24 September 2025

File No: NTH24/00244/005
Your Ref: SSD-65595459

Review of Response to Submissions (SSD-65595459), Hunter Indoor Sports Centre, Lot 2380 DP755247, Lot 2379 DP755247, Lot 2378 DP755247 and Lot 2377 DP755247, 2 Monash Road and 24 Wallarah Road New Lambton

250106-DA-360-01

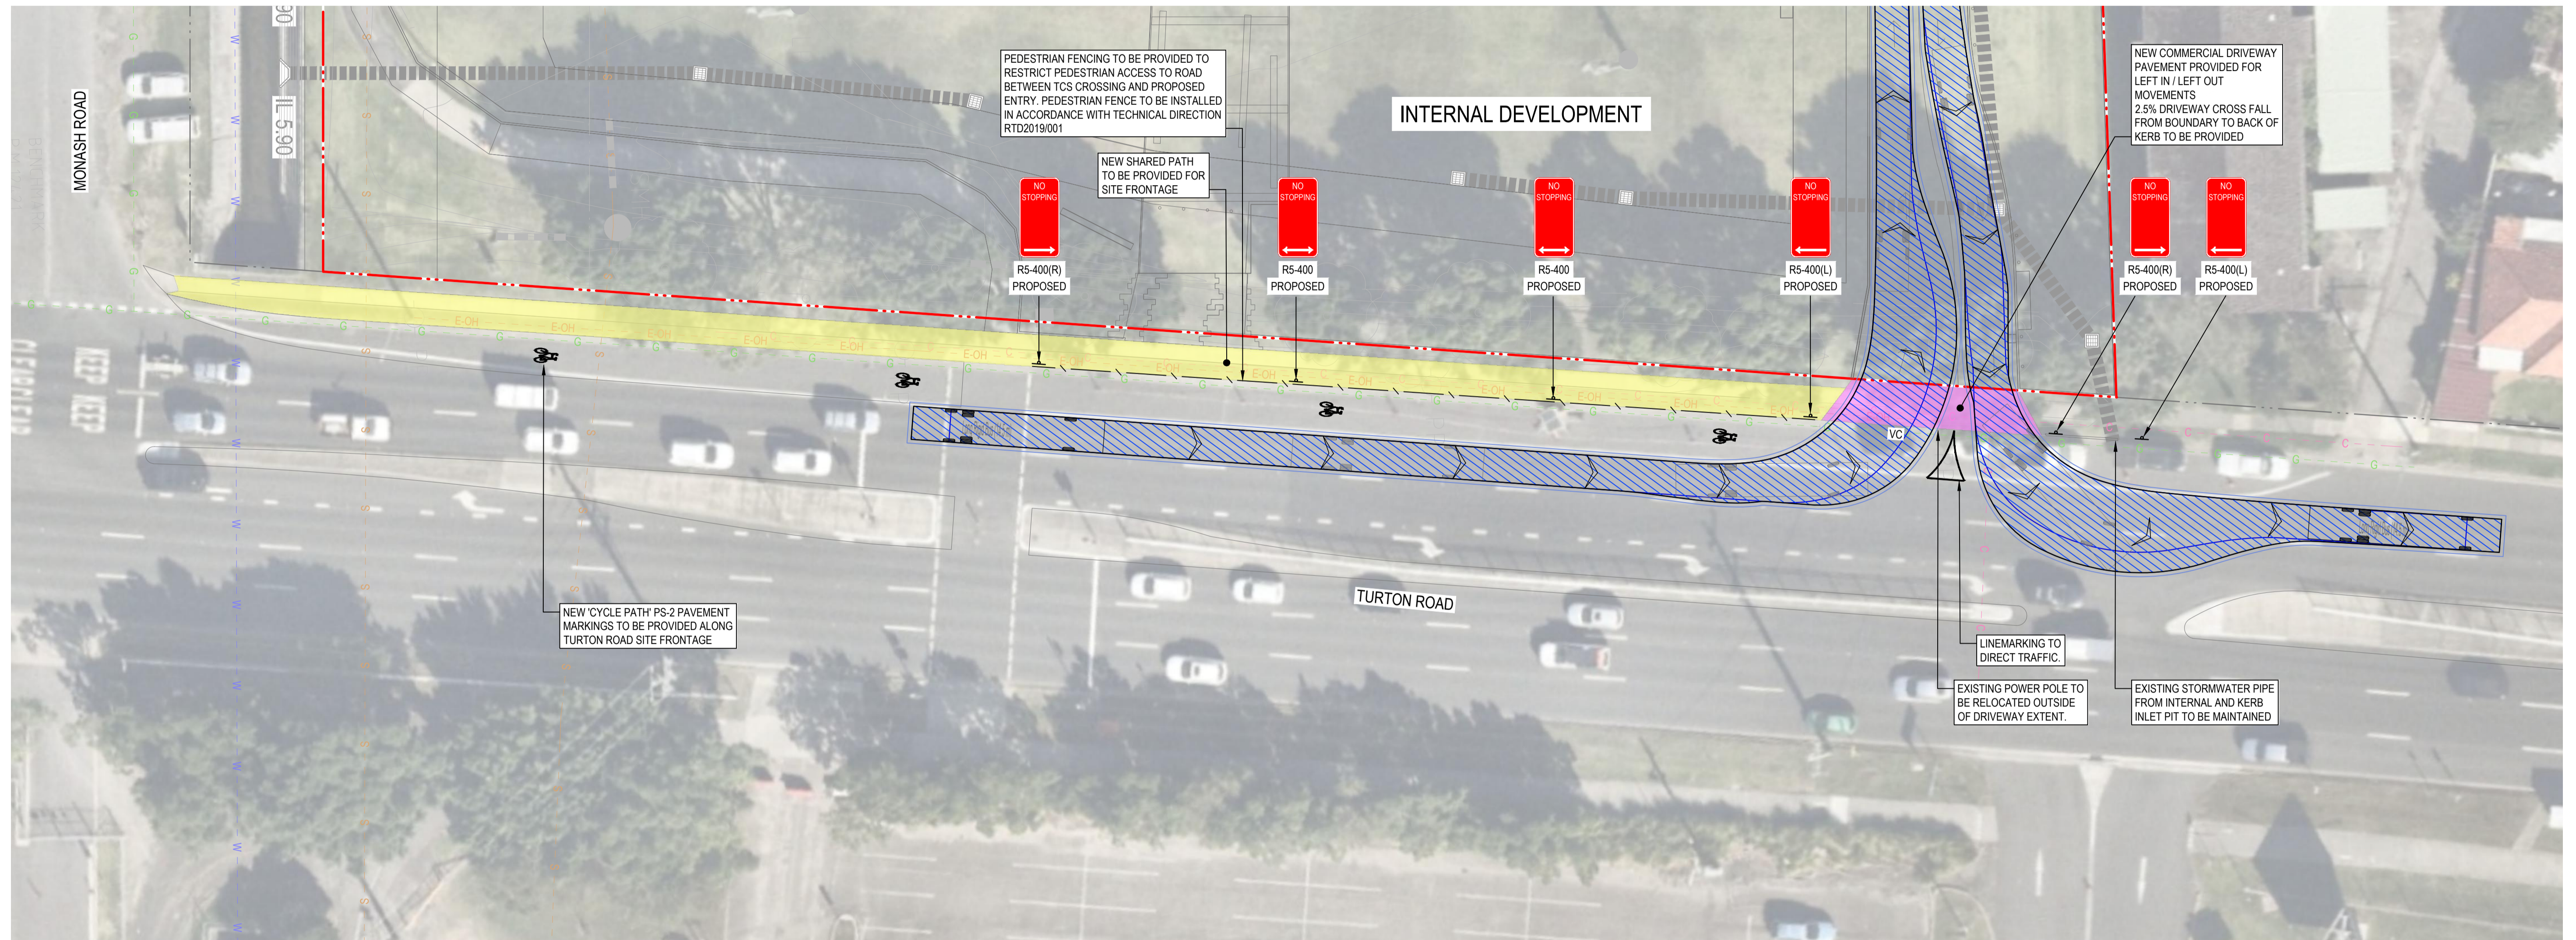
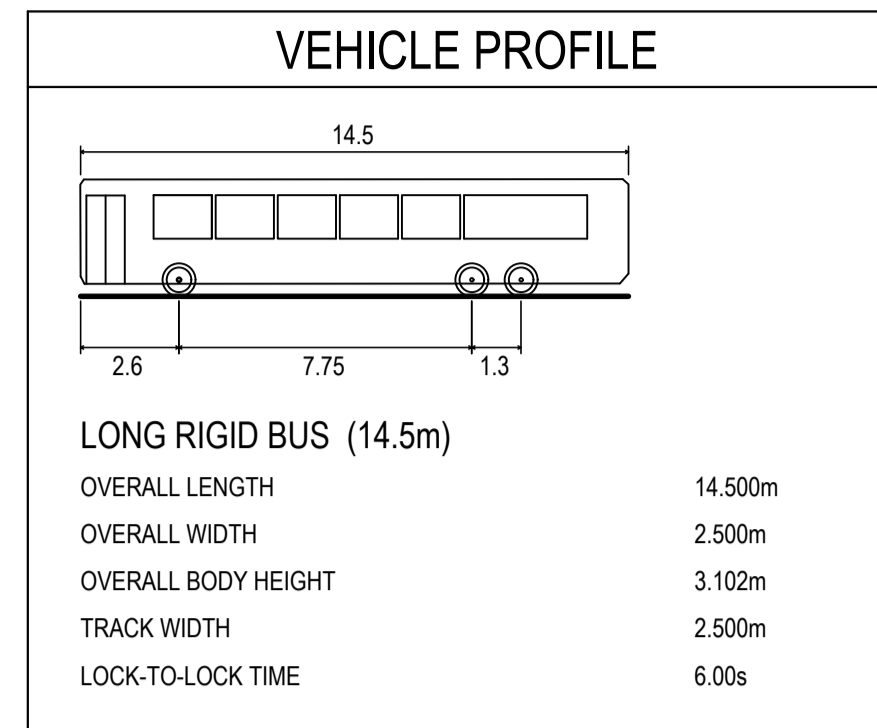
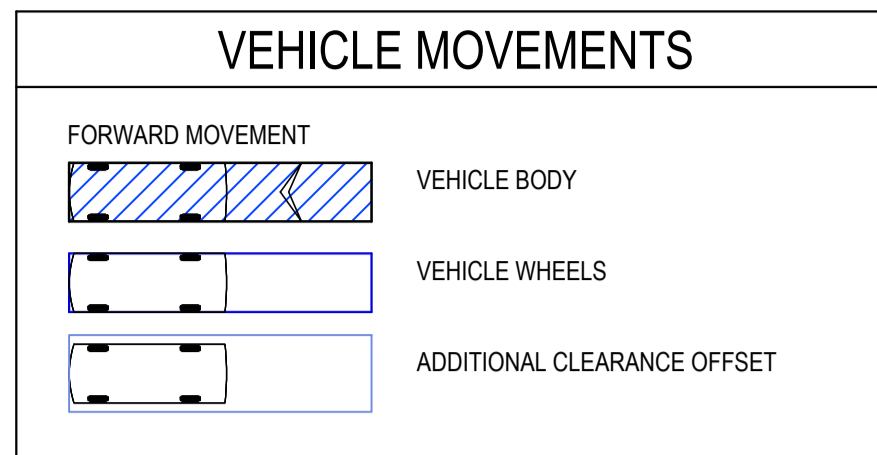
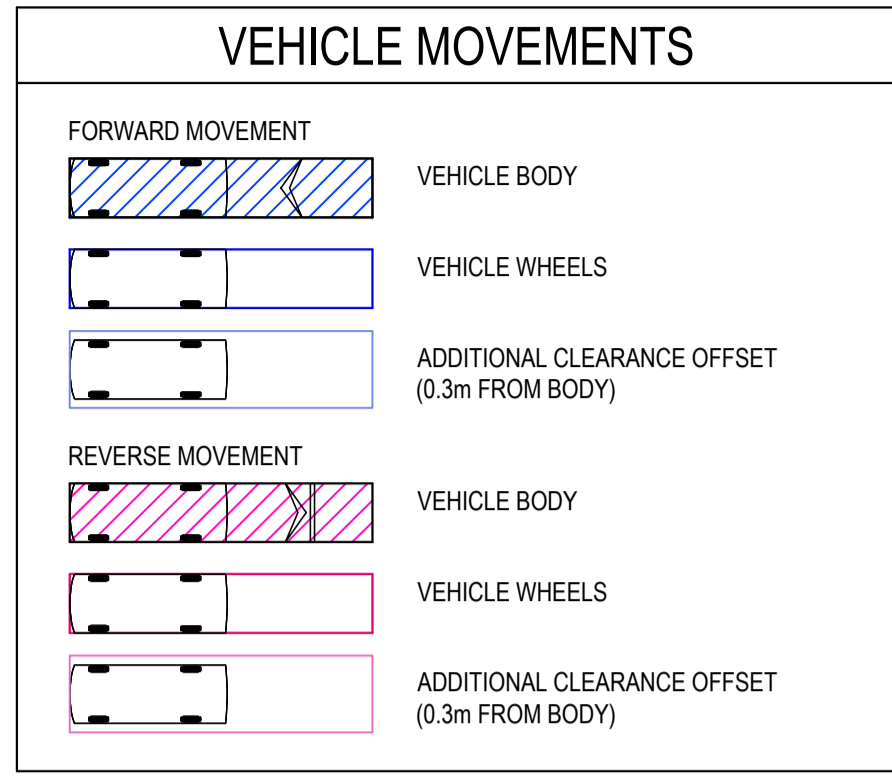
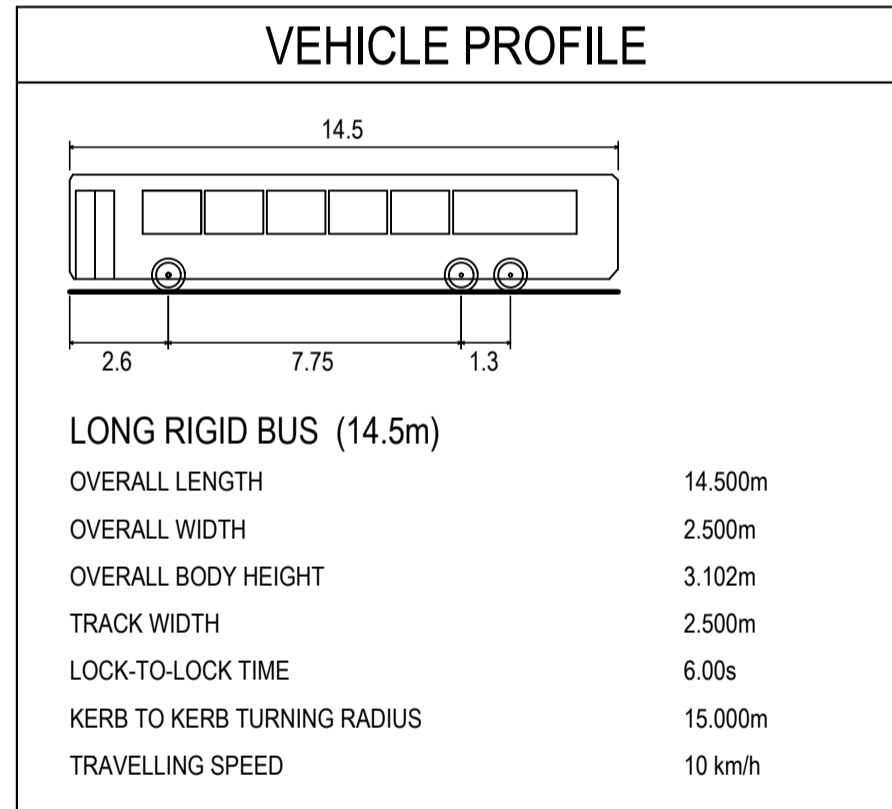
- a. Plan 250106-DA-030-01 Rev 3 should be updated to remove references to a left turn lane into the site entrance.
- b. Plan 250105-DA-360-01 should be updated to include:
 - i. Amendment of the 'No Stopping' signs and additional signs added as per the sketch below. Alternatively, use of the NS1 line marking may be more beneficial and reduce the number of no stopping signs required.

- ii. The small painted island at the driveway entrance obstructs the on-road cycle area and should be pushed back into the driveway layback area
- iii. A left only arrow should be installed in the driveway layback
- iv. No U-turn signage should be installed at the intersection with Monash Road to deter this movement.
